DESCRIPTION OF REQUEST: 9,000 SF Dialysis Facility to be built in the city of Albuquerque

Re: Liberty Dialysis – Rio Rancho
CKA Project #11098-01
COA Project # 1009325

This letter is in response to the EPC Official Notice of Decision dated August 9, 2012. I have structured this letter stating your comments first, followed by my response in bold italics. My response is as follows:

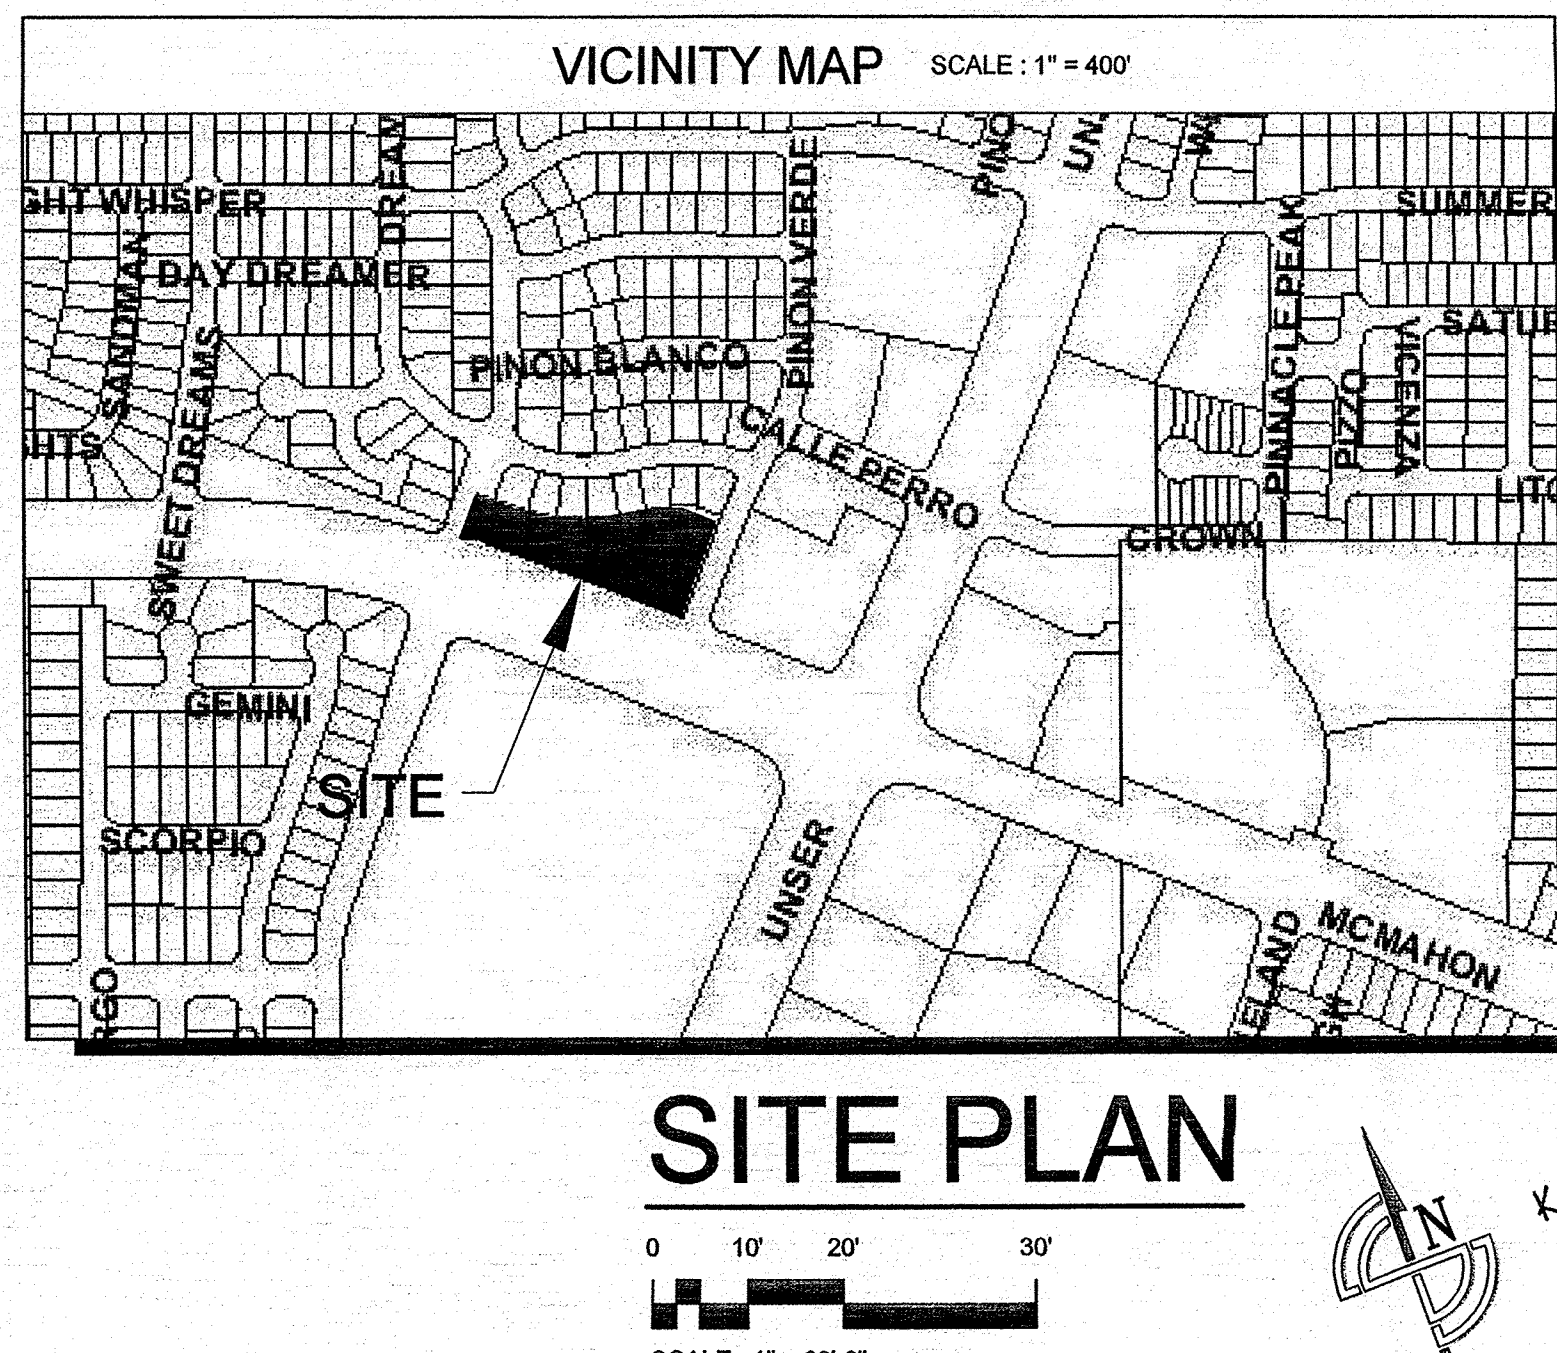
3. Site Plan for Building Permit, Sheet 1:
 - a. Correct the zoning information for adjacent properties under the section "Surrounding Zones." The information provided is more descriptive of surrounding uses, not zoning.

- b. The Parking data should be revised to indicate the "Maximum" Curb Cut width is 32 feet.

- c. The walls bounding the outdoor patios should indicate the wall height, material and color.

4. Pedestrian/Bicycle Access:
 - a. Pedestrian Connections shall be provided across the site directly to Bandelier Dr., which also connect to the two parking areas west of the building.

- b. Colored and stamped concrete surfaces shall be provided where pedestrian walkways cross the drive aisles.

CKA Response: Section has been updated as requested.

CKA Response: Parking data has been revised to show "Maximum" Curb Cut width as 32 feet.

CKA Response: Height, material, and color have been added for the half walls at the outdoor patios.

CKA Response: A 6 foot wide sidewalk has been added as the connection across the site to Bandelier Dr.

CKA Response: Colored and stamped concrete surfaces have been added at all pedestrian walkways cross

**1A**

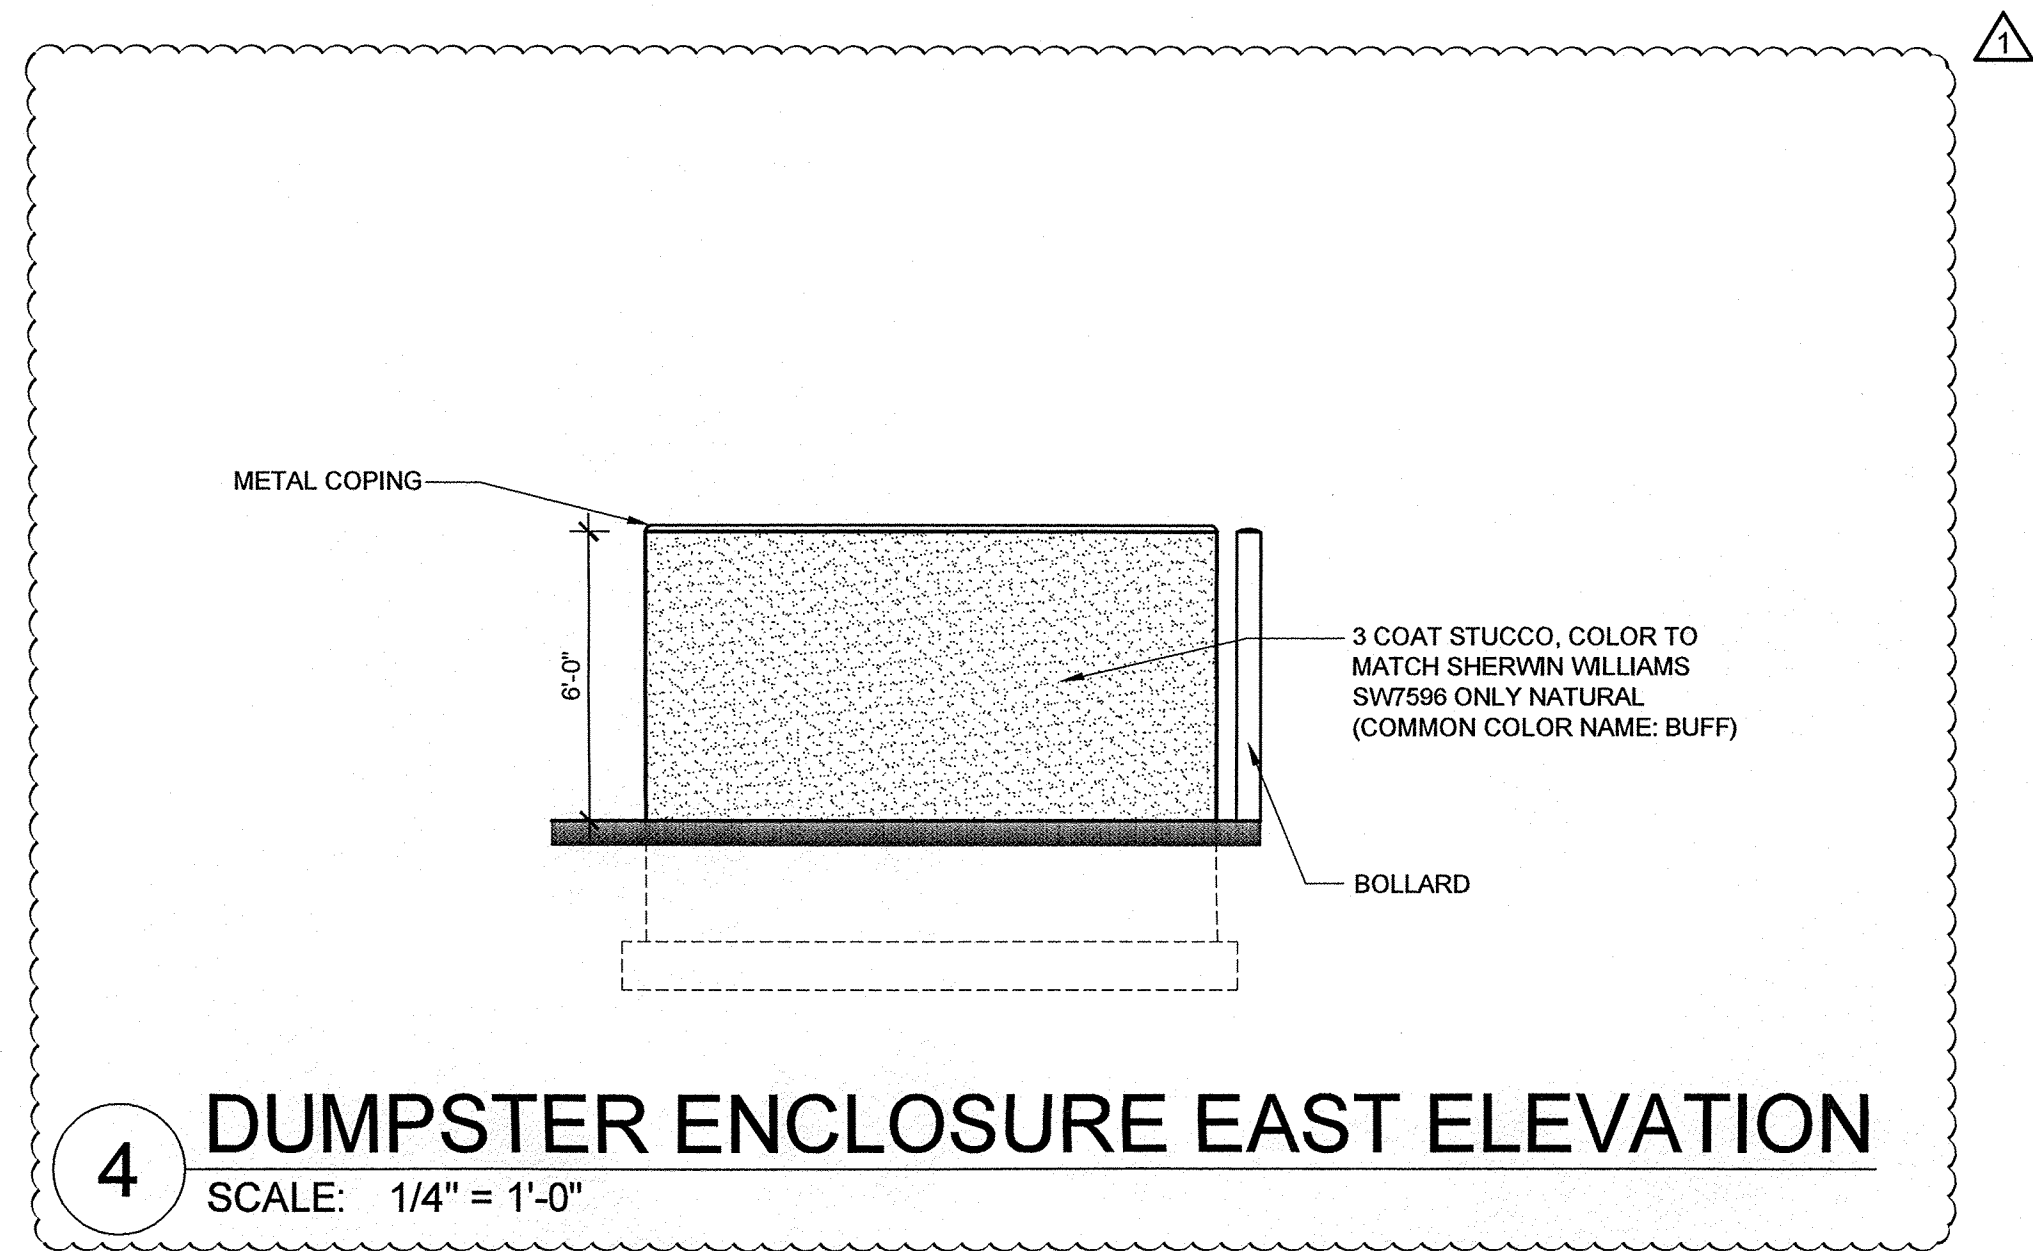
- d. The classification and size of design vehicle needs to be provided for the turning templates shown on site plan.

CKA Response: Turning template used for the large vehicular access is a WB-40 Template. Vehicular circulation patterns are shown on Sheet 1A of the submittal.

**1B**

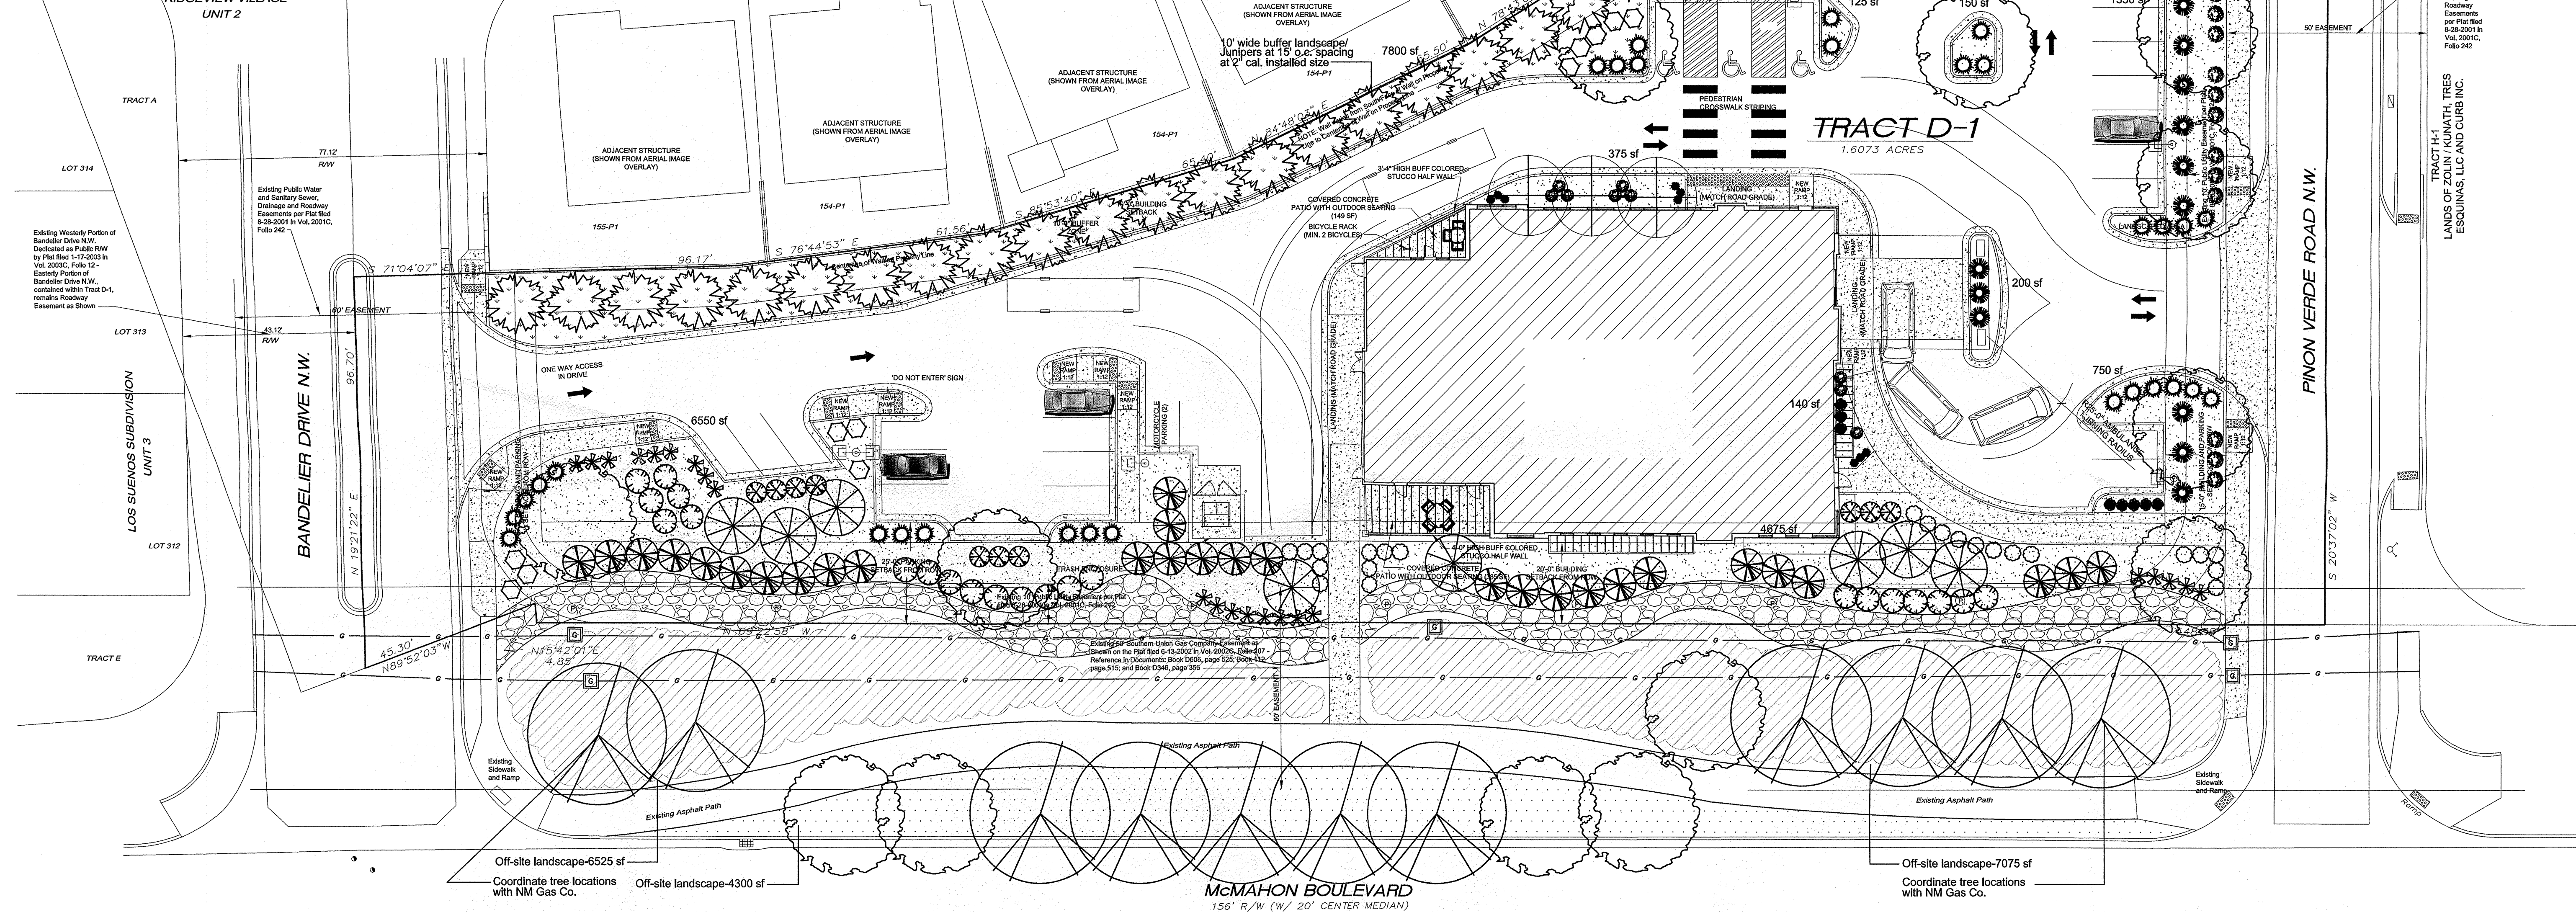
- a. The applicant shall consult with NM Gas Company to determine their policies for landscaping in a utility easement. The Vitex Trees shall be relocated if they conflict with the underground gas line.

- b. The minimum tree size at the time of planting shall be 2" caliper or 10 feet in height. The legend shall be revised to reflect this minimum planting size.

- c. The height and canopy spread of the Chinese Pistache shall be verified. The plant sizes shown on the landscape plan are not consistent with the 60' canopy described in the plant legend.

- d. The landscape plan may be adjusted such that the amount of the live vegetative plant material is equal to at least 11.25% of the site.

The Landscape Sheet 2 has been revised by relocating the Vitex to avoid this conflict.

Tree sizes have been changed to be 2" caliper minimum.

The Chinese Pistache canopies have been modified to more accurately depict a realistic coverage size for Albuquerque.

The Landscape Plan has been modified to reduce the planting quantity resulting in a more affordable plant quantity.
